LIFE NETWORK
 INTERIOR REMODEL
 7184 NORTH MERIDIAN ROAD
 COLORADO SPRINGS, CO 80831
 EL PASO COUNTY, COLORADO

SITE PLAN
 SCALE: 1"=20'-0"

1 SITE PLAN  
SCALE: 1"=20'-0"

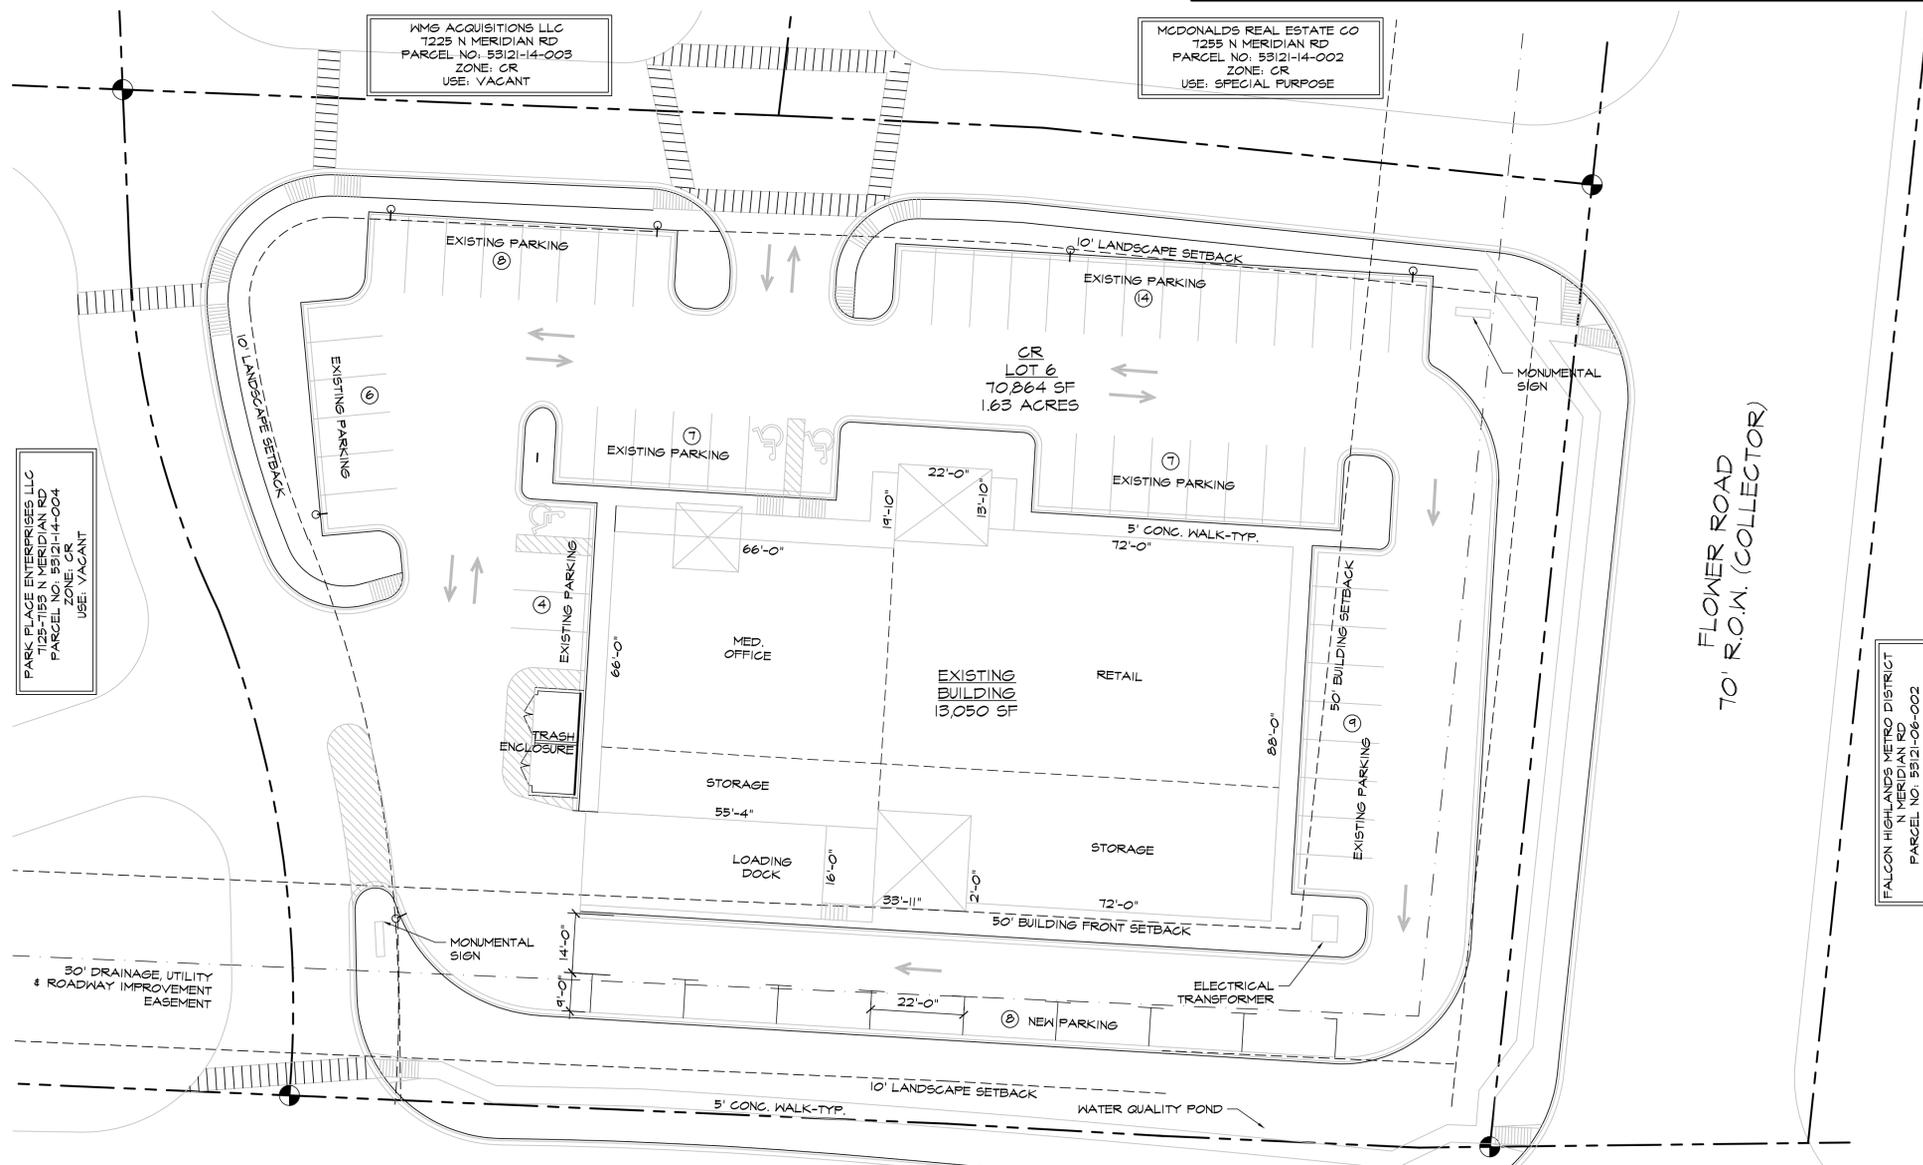
Please resubmit requesting "Alternative Parking Ratio" instead of requesting Admin Relief.
 Alt Parking Ratio Criteria for Approval is in Section 6.2.5.D.vi.
 Update the letter of intent and respond to the different criteria for approval within it.
 Suggested alternative ratio could be:
 -1 space per 300SF for Medical Office (requiring 11 instead of 16)
 -1 space per 300SF for Retail Space (requiring 19 instead of 23)
 -1 space per 300SF for General Office (requiring 26 instead of 31)
 Reducing total required from 74 to 61 with 63 provided.
 Justification being the lot is already built out, you've committed to adding as many spaces as physically possible, the pregnancy center is likely to be visited by more than one person per car, and the retail store is intended to serve the same people coming to the pregnancy center.
